**From:** Speakman, Glenn - Oxfordshire County Council  
<Glenn.Speakman@Oxfordshire.gov.uk>  
**Sent:** 20 January 2022 11:12  
**To:** Michael Sackey; DC Support  
**Cc:** Transport CDC Minor; Cllr Ian Corkin  
**Subject:** 21/04134/F Part Of OS Parcel 5720 East Of Kyleburn And West Of Manor Farm,  
Main Street, Wendlebury

**Planning application:** 21/04134/F  
**Location:** Part Of OS Parcel 5720 East Of Kyleburn And West Of Manor Farm, Main Street, Wendlebury  
**Description:** i) Relocation of existing field access, and,  
ii) Permanent closure of existing gateway.  
**Case Officer:** Michael Sackey

DO NOT SCALE
Contractor to check all dimensions on site and report discrepancies before proceeding.
This drawing is copyright.

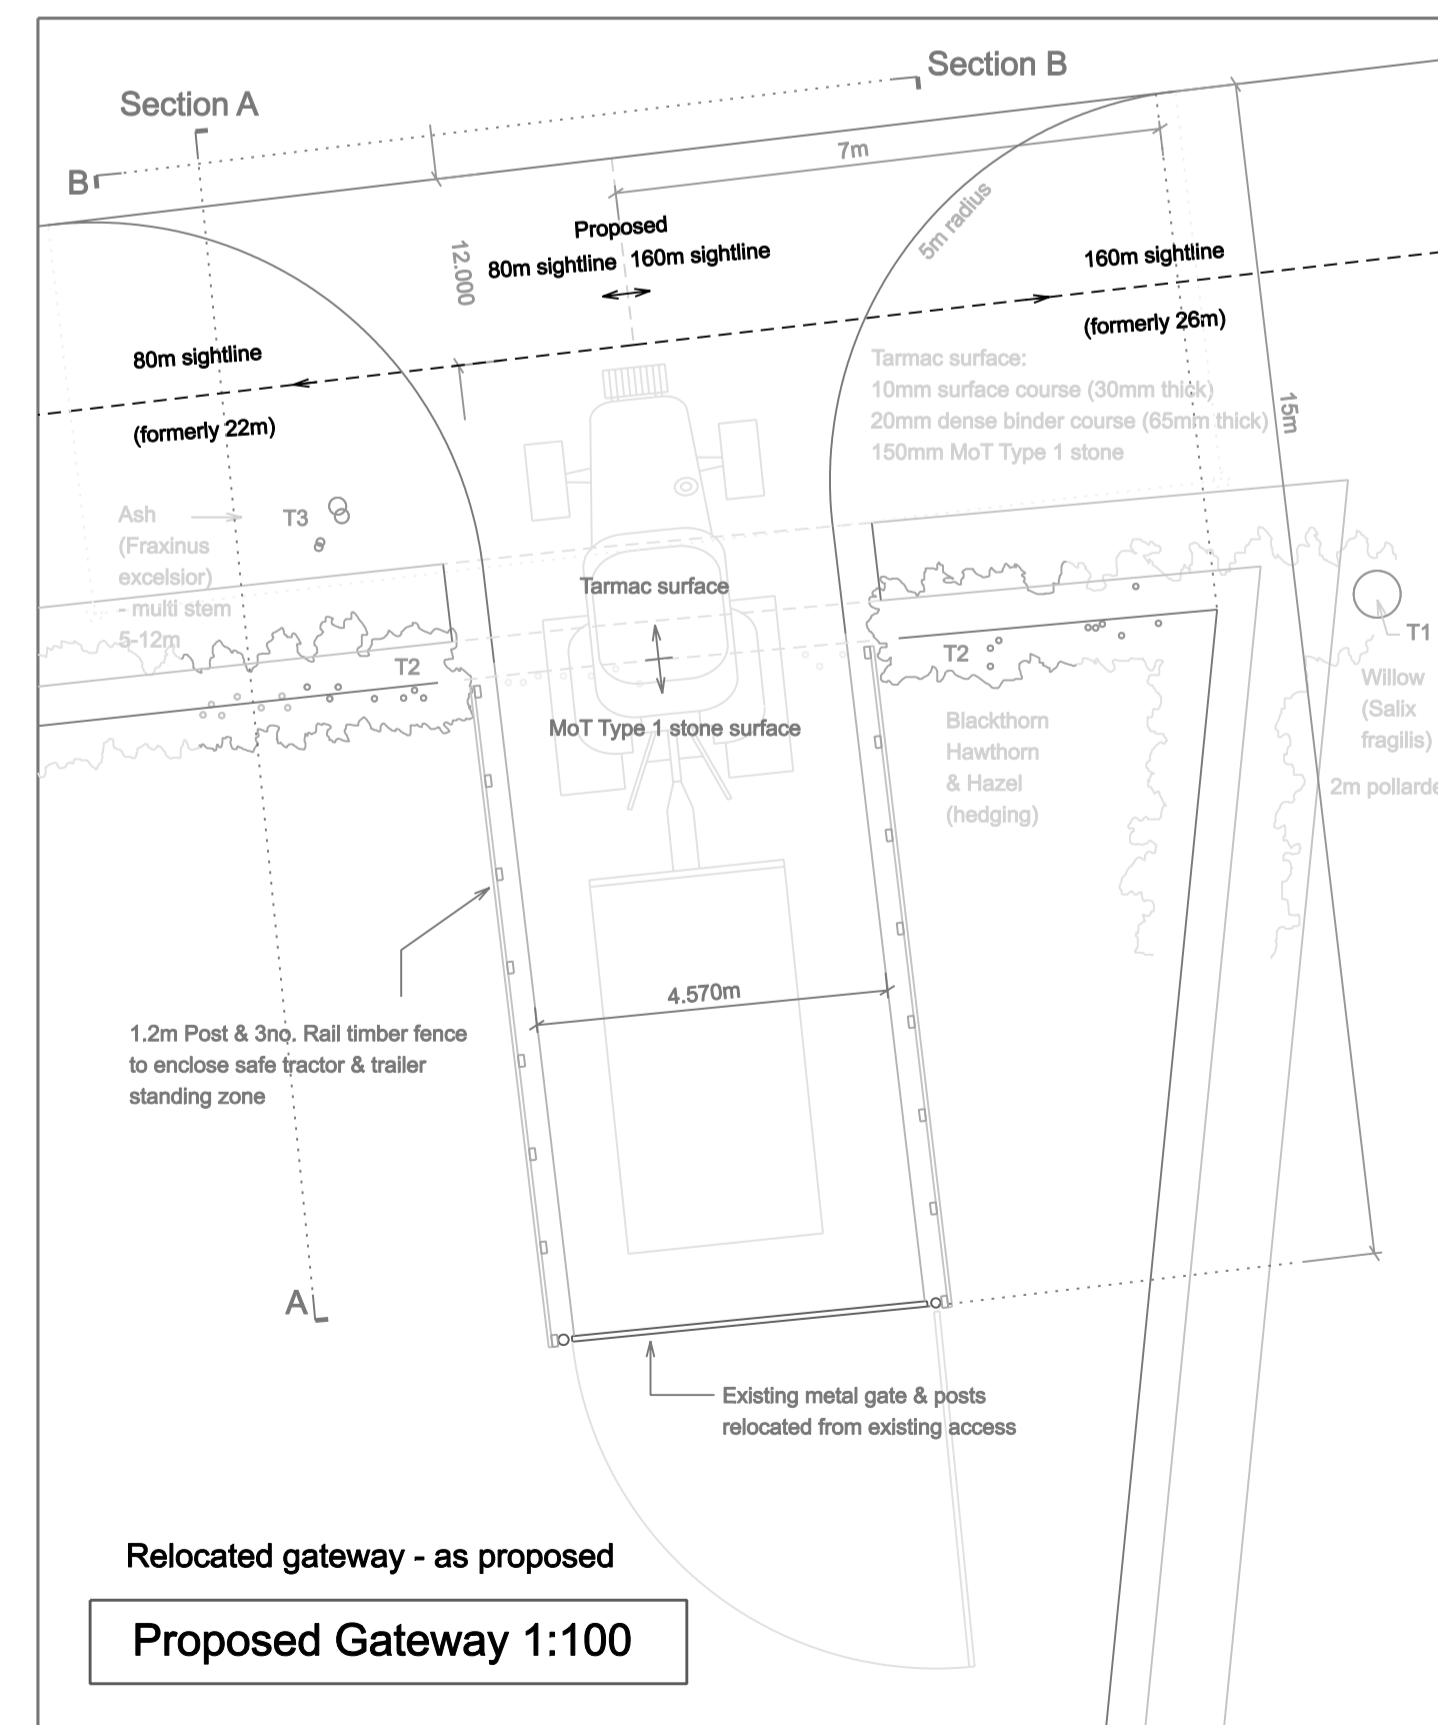
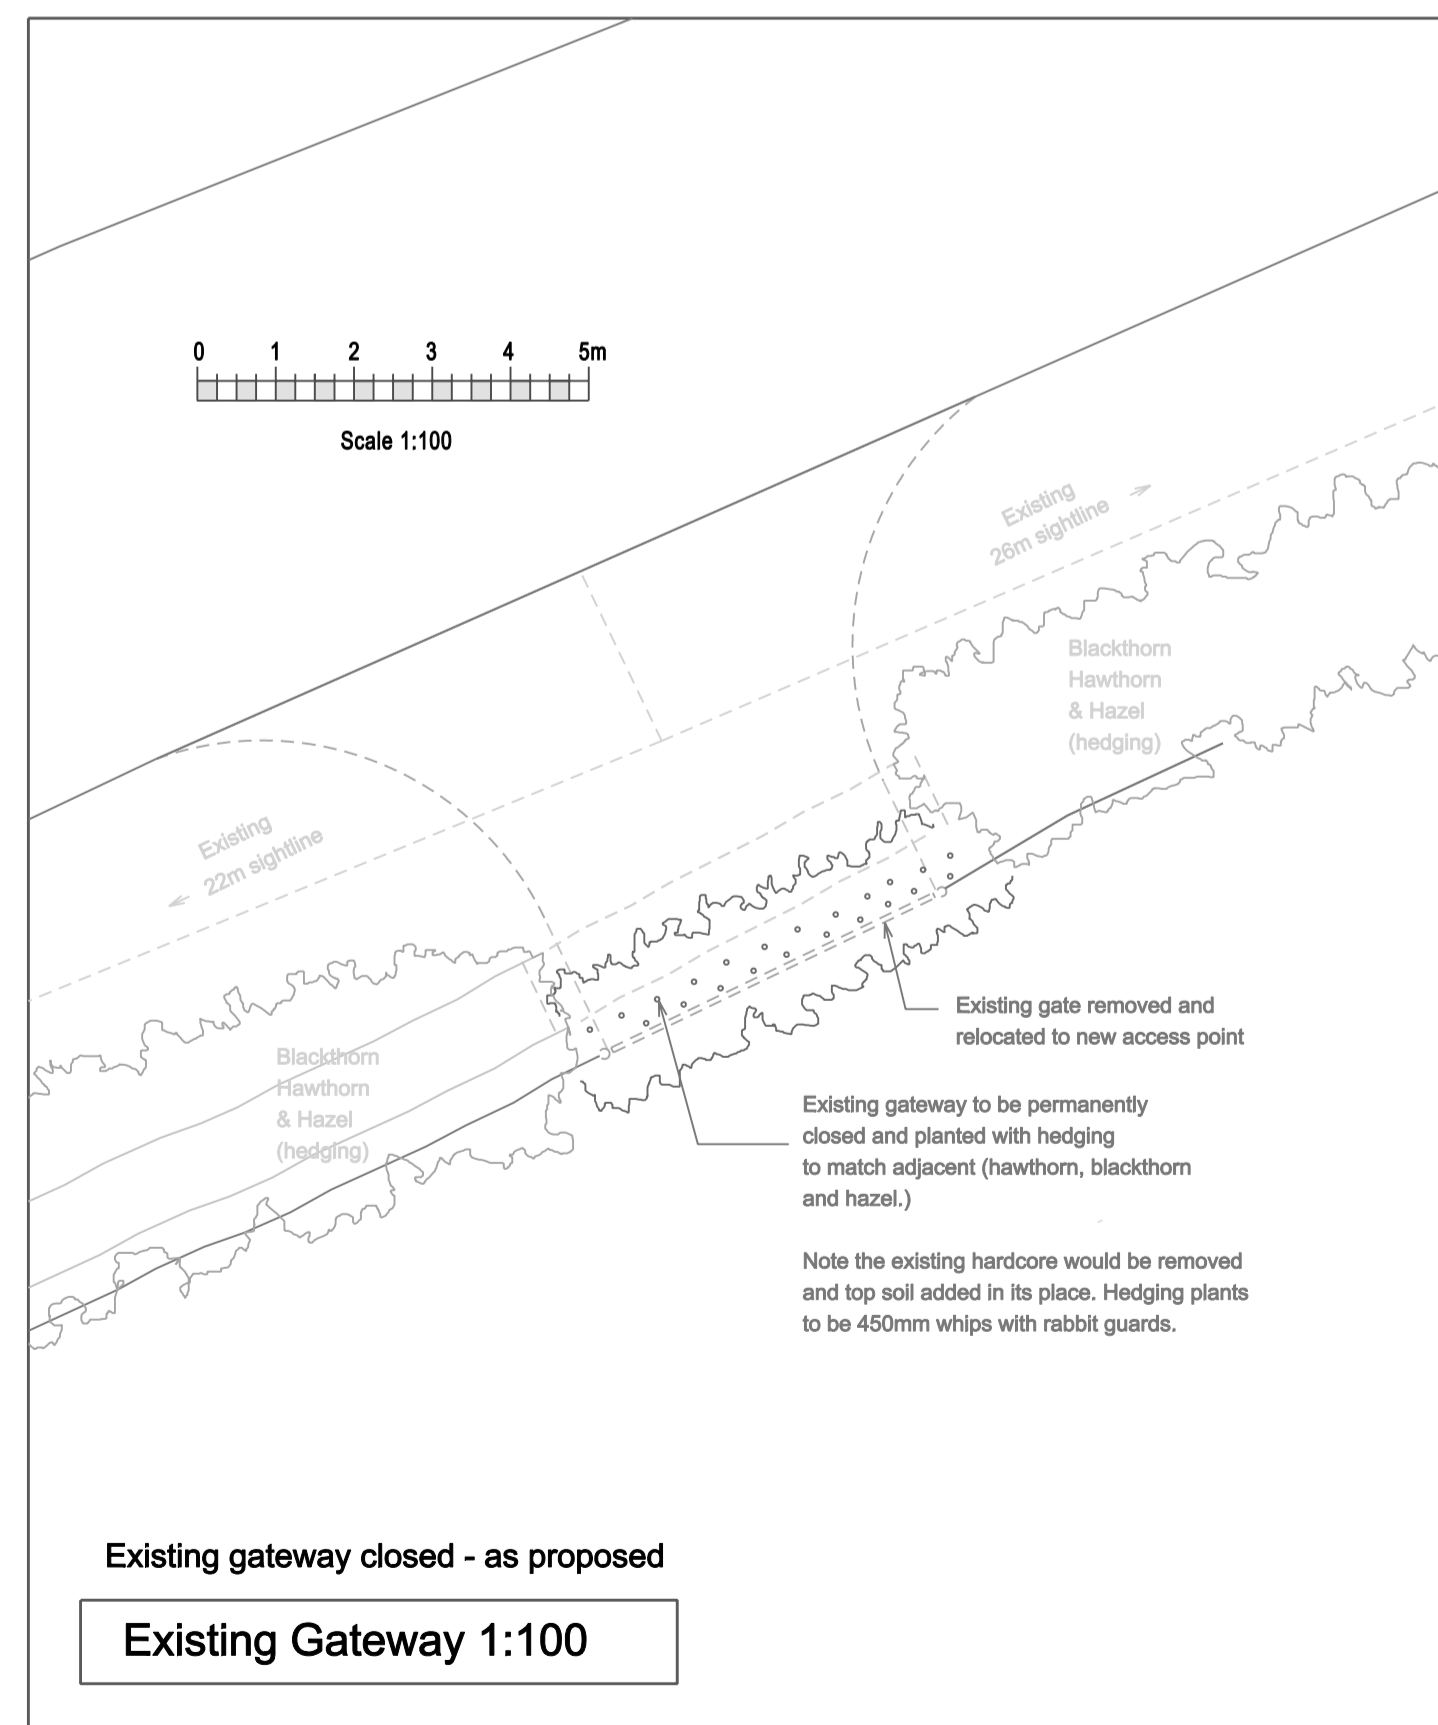
The proposals represent a severely sub standard access being improved and made substantially safer. The western splay of 80m would still be considered sub standard according to guidelines. Despite this, the access has been relocated into the best possible position and the application will not increase the number of vehicle trips at the access.

The proposals are therefore unlikely to have any adverse impact upon the local highway network in traffic and safety terms, OCC do not object to the granting of planning permission.
